MADDOX PLANNING

**22/02025/REM: BICESTER GATEWAY PHASE 1B
RESERVED MATTERS APPLICATION TO APPROVED OUTLINE REF: 16/02586/OUT
LANDSCAPING RESPONSE; SECURE BY DESIGN RESPONSE; HIGHWAYS**

**04** Type 4 - Elevation View  
 PLANTER TREE PIT DETAIL  
 1:20

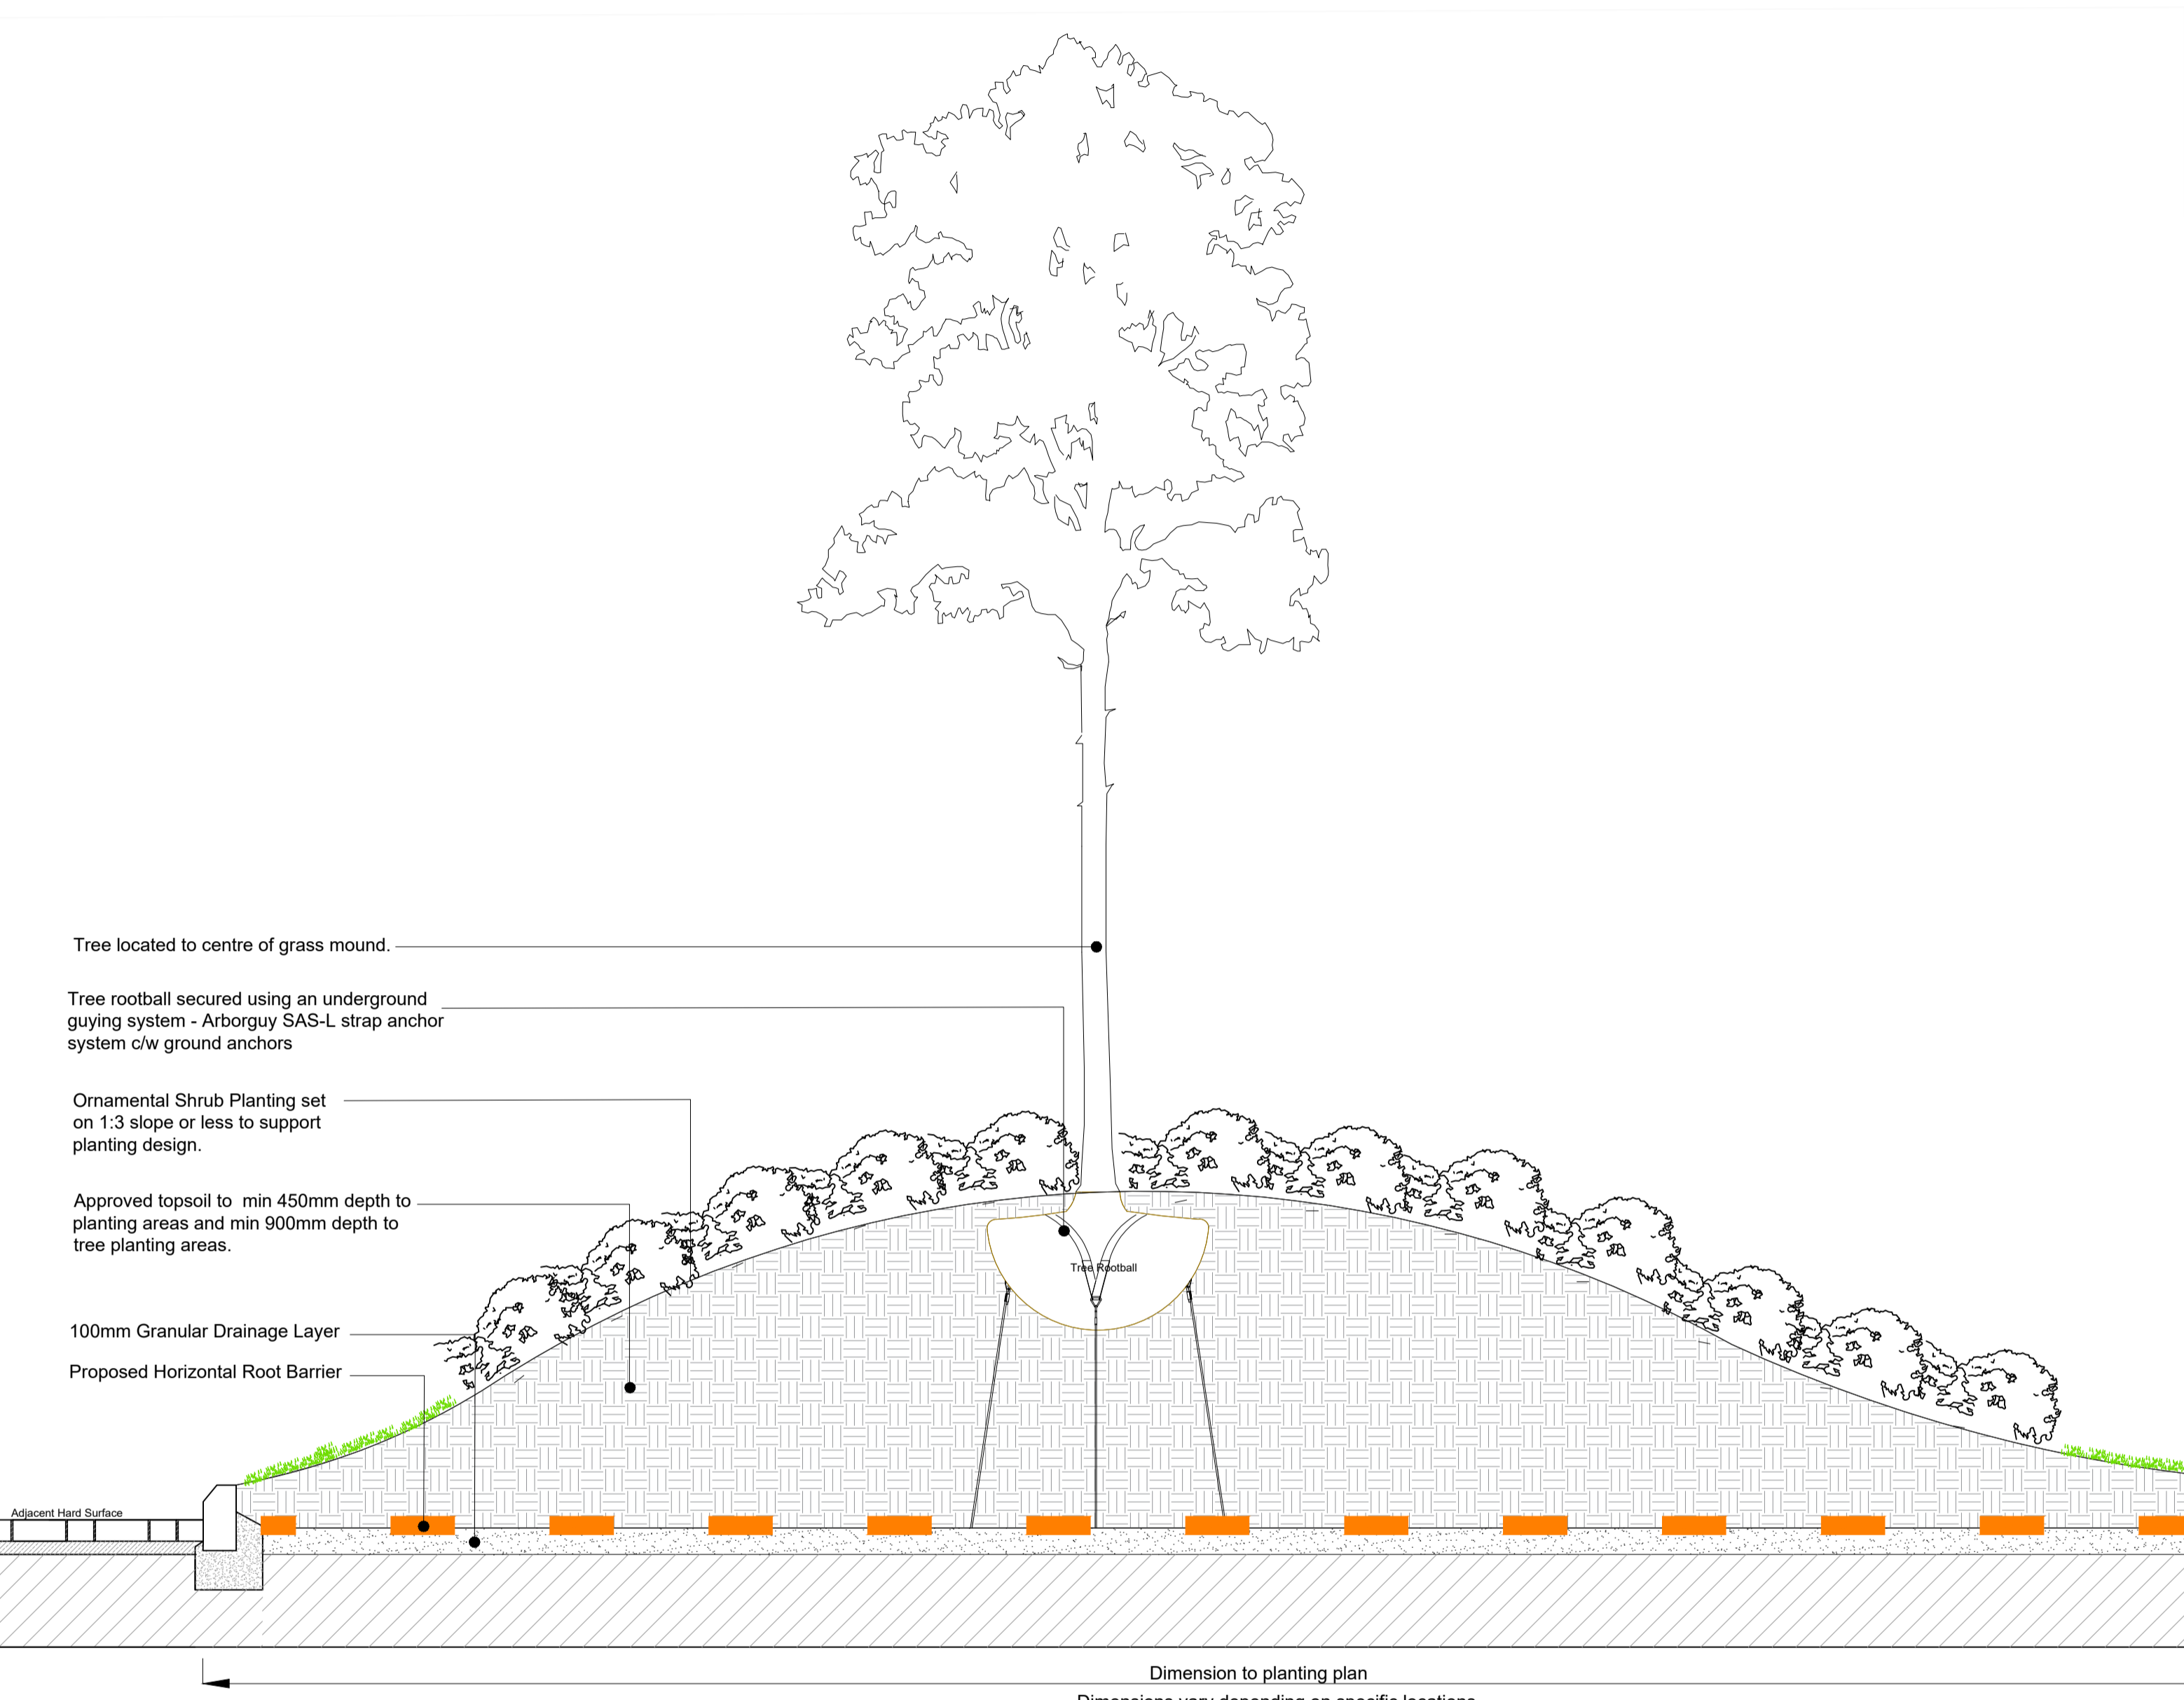
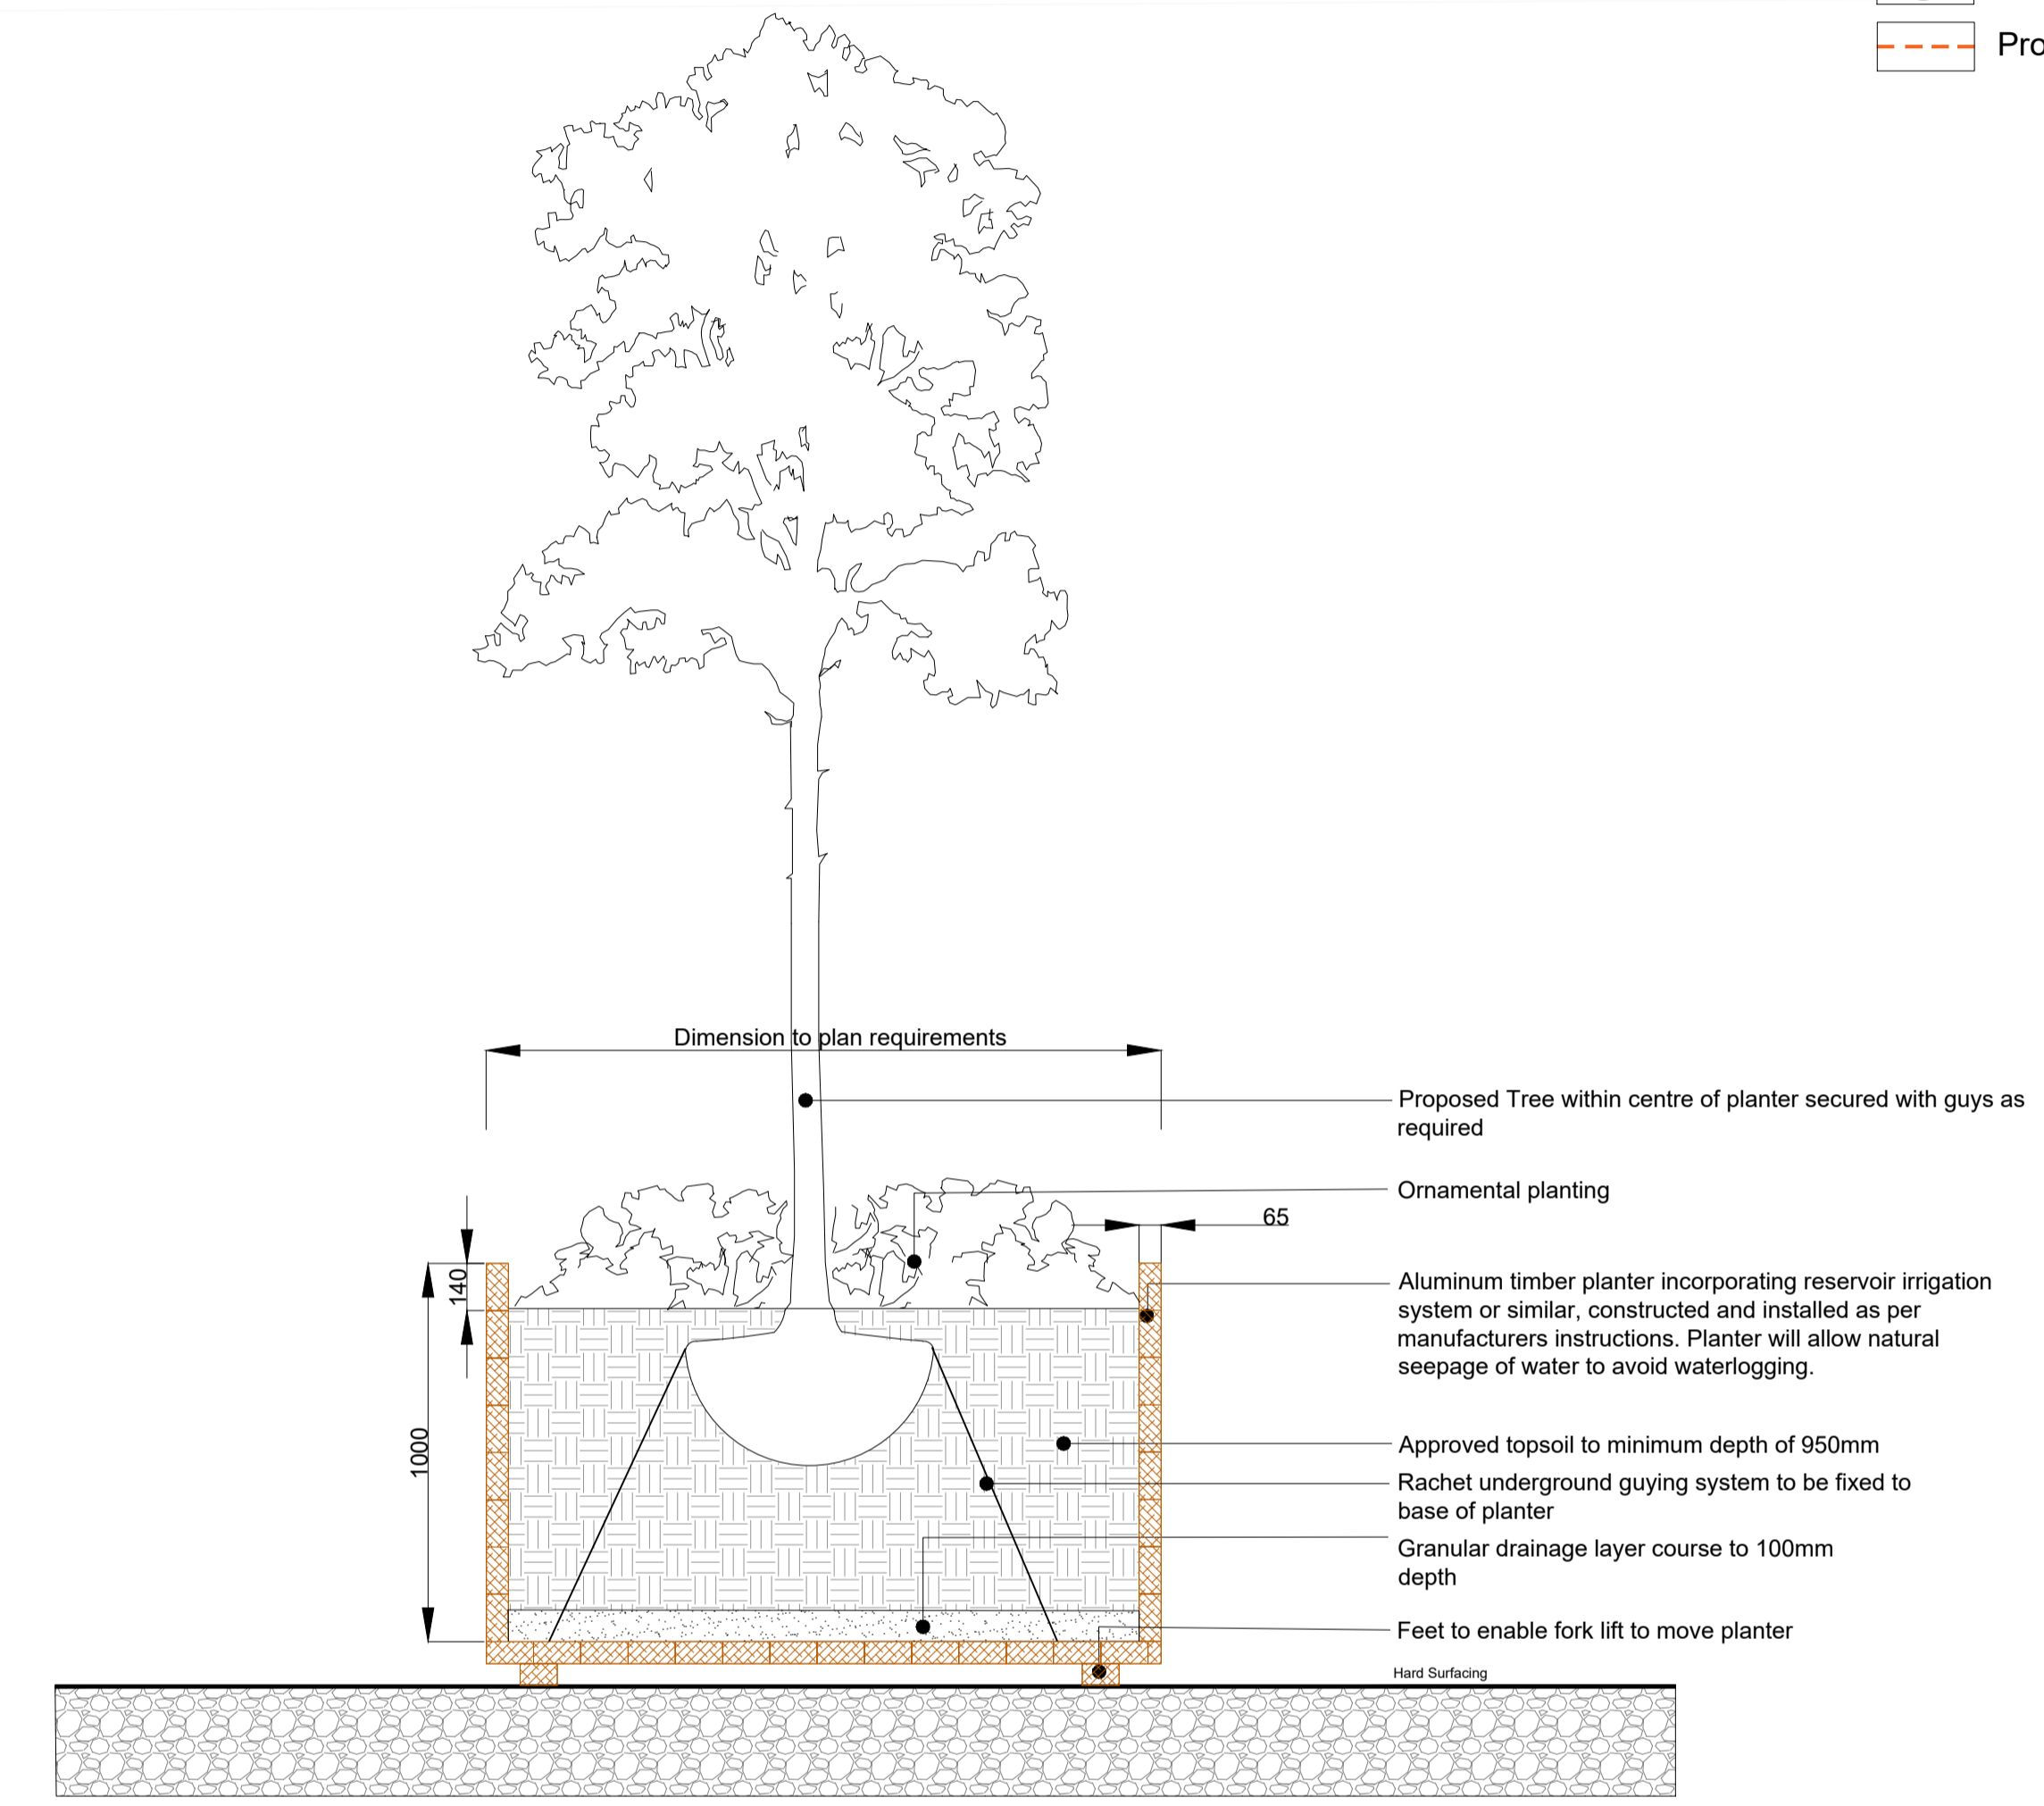
-
- Installation of 1m wide planters in the area of “preservation in situ” in between some of the parking spaces to include planting and additional small trees to help break up the parking area, as well as meet officer comments on mitigating the heat Island effect, provide amenity and wildlife value;

The team has taken comments on board and sought to respond positively. The landscape plans are amended (enclosed) to make the archaeological area “preservation in situ” clearer. The plans and the landscape management plan (LMP) now include the following:
